11 Bryant Street
Duplex

**CITY OF PORTLAND, MAINE
DEVELOPMENT REVIEW APPLICATION
PLANNING DEPARTMENT PROCESSING FORM
Planning Copy**

RE: Duplex, 11 Bryant Street
ID #2005-0183, CBL #129-C-003

From: Lynda Clayton
To: Sarah Hopkins
Date: 09/27/2005 3:55:21 PM
Subject: 2 unit modular home/condo's @ 11 Bryant ST - Site Plan Review

Site Plan
11 Bryant Street
Portland, ME

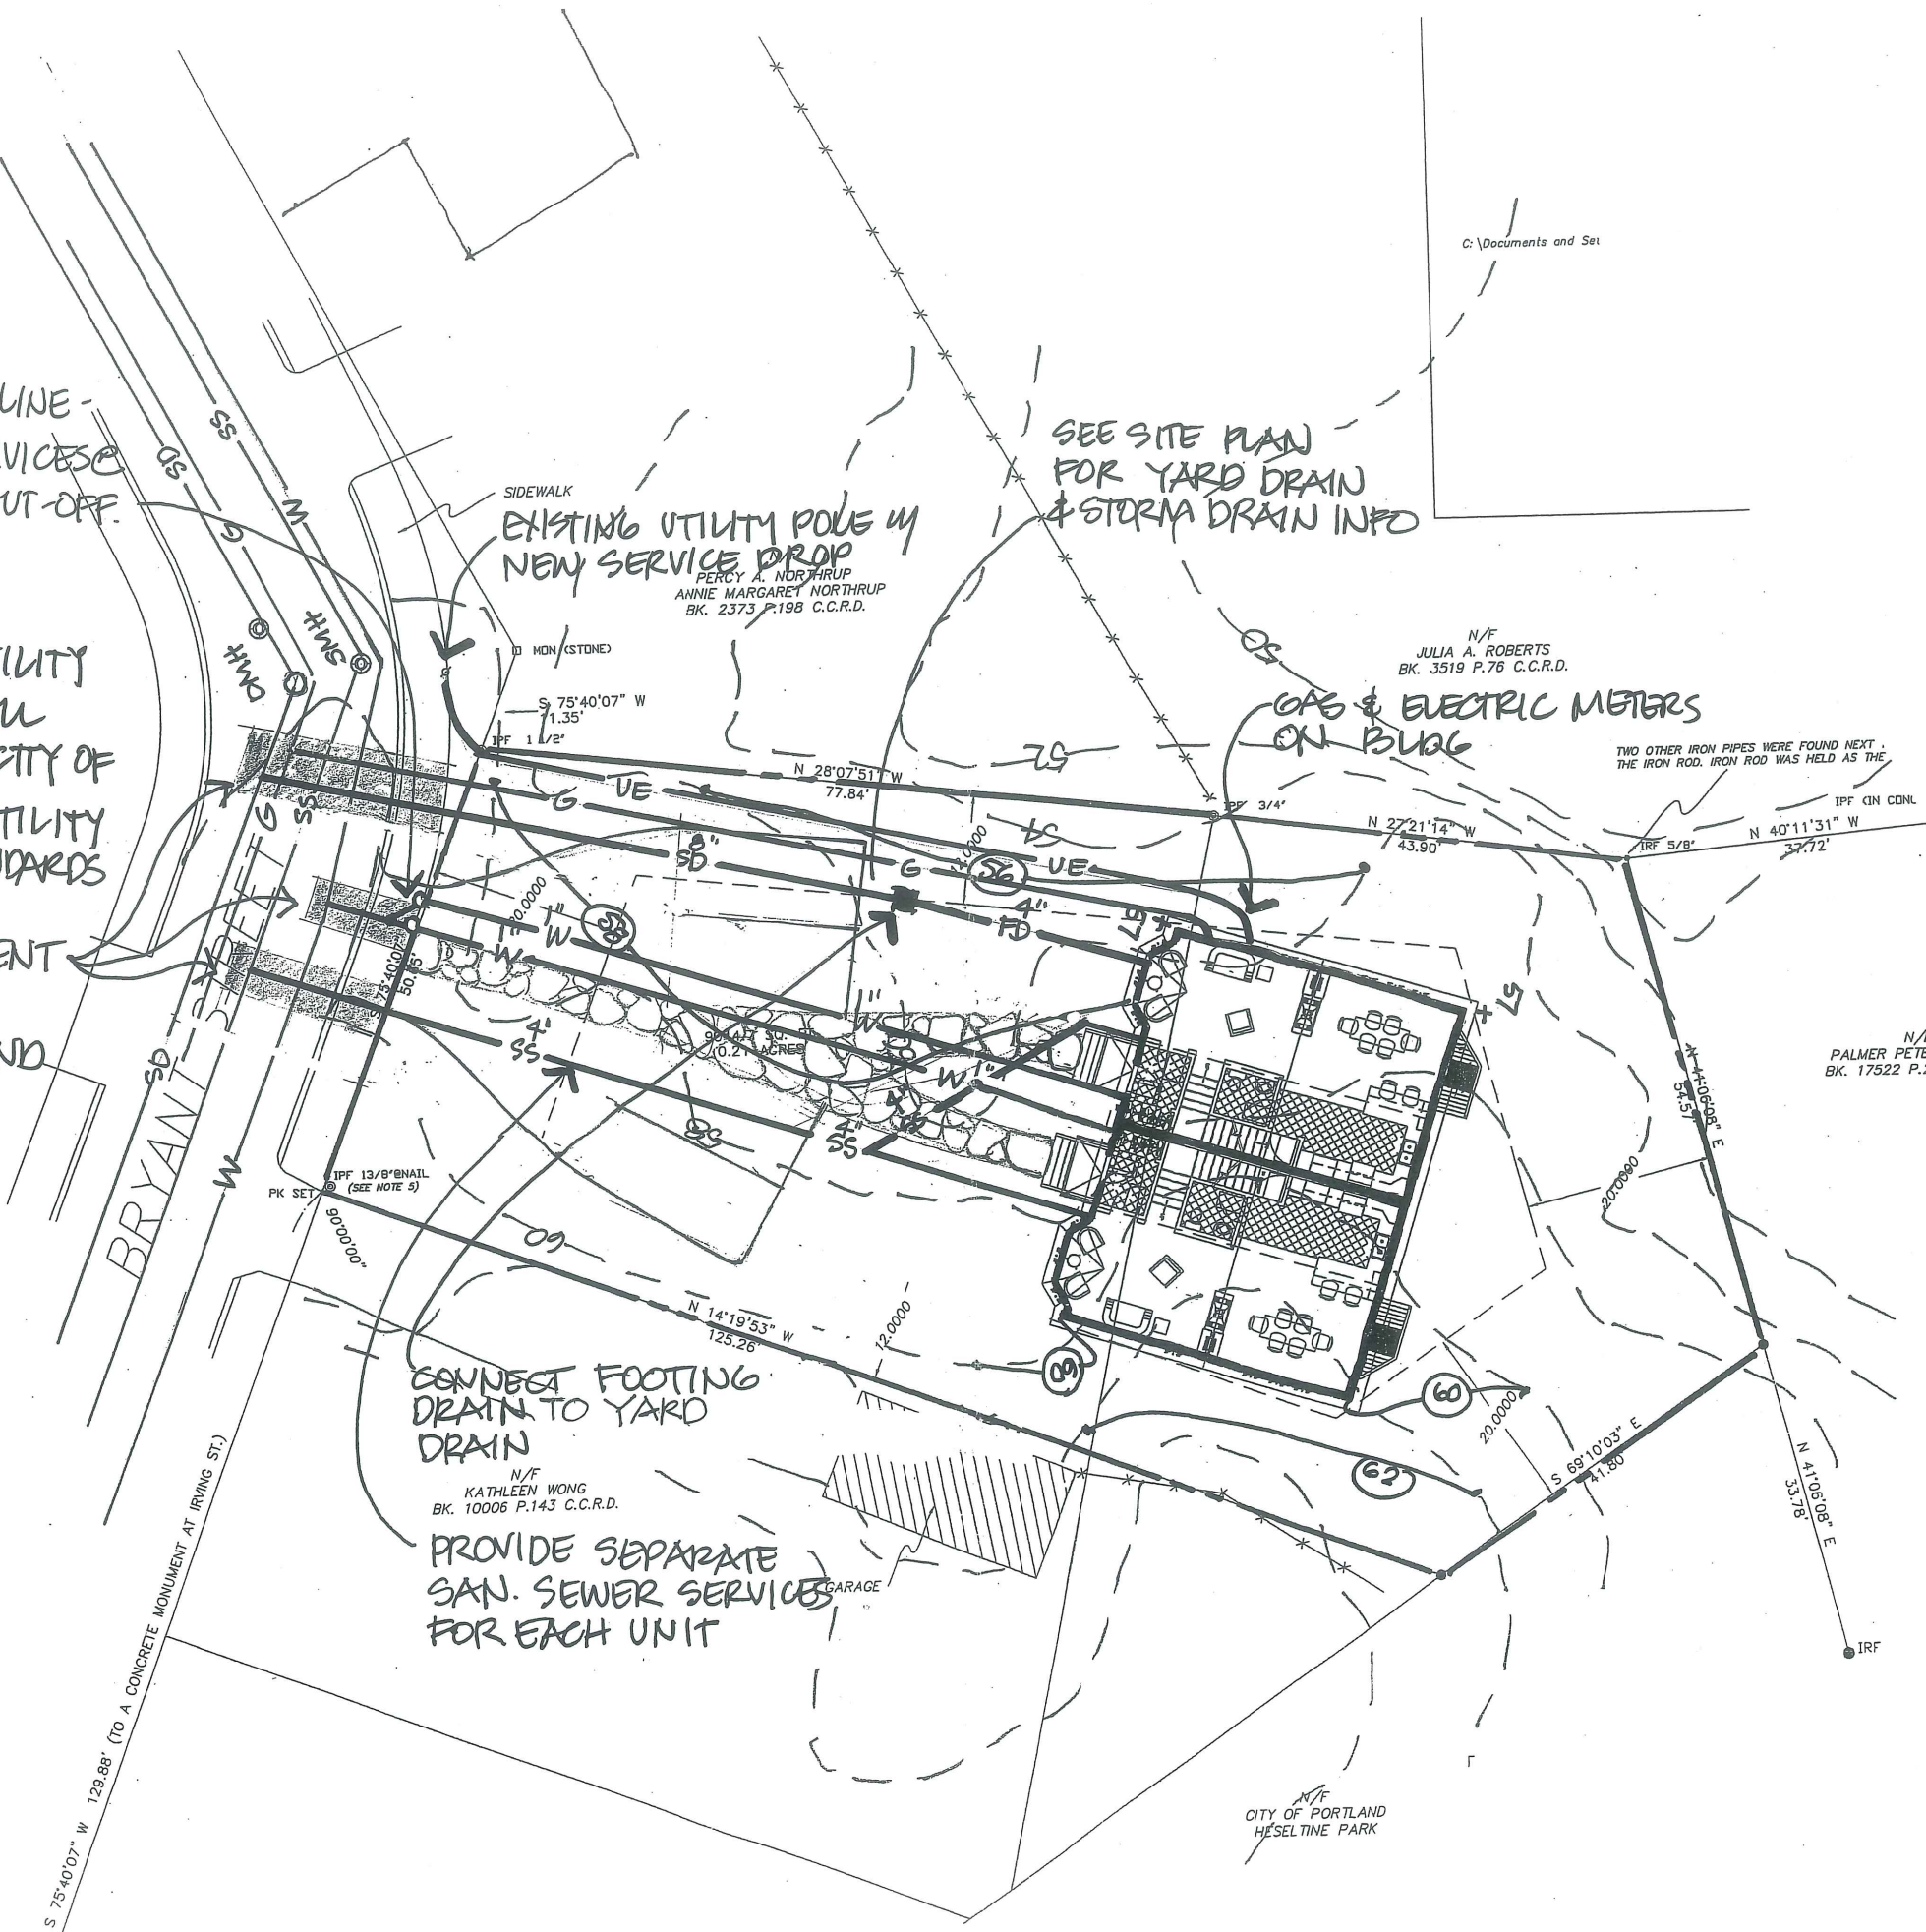
"Site Plan" (Sheet 1 of 7 submitted)

**This site plan has no North arrow.
Our Technical and Design Standards call for Grid North (Page I-3).**

Owner name and deed reference are not given for the locus parcel.

The "Site Plan" is not stamped. A Professional Land Surveyor stamp is required for any boundary plan.

**Notes about monumentation are referenced which are not on the plan provided.
Specifically, Note #5.**

**There is no benchmark description or elevation shown.
How were contours and invert elevations established???
The site plan does not describe what was specifically used as the basis for elevations.**

It is not clear from the plan what was specifically used / held by the surveyor to locate this lot as shown (i.e. boundary markers used, record distances or bearings used, etc.).

It is not clear from this plan what was specifically used / held by the surveyor to establish the City street lines of the streets shown.

A note should be added to warn the contractor to protect all apparent property markers found on this site, and clearly stating that it's the contractor's responsibility to pay a Professional Land Surveyor to replace any markers that are destroyed or uprooted during construction.
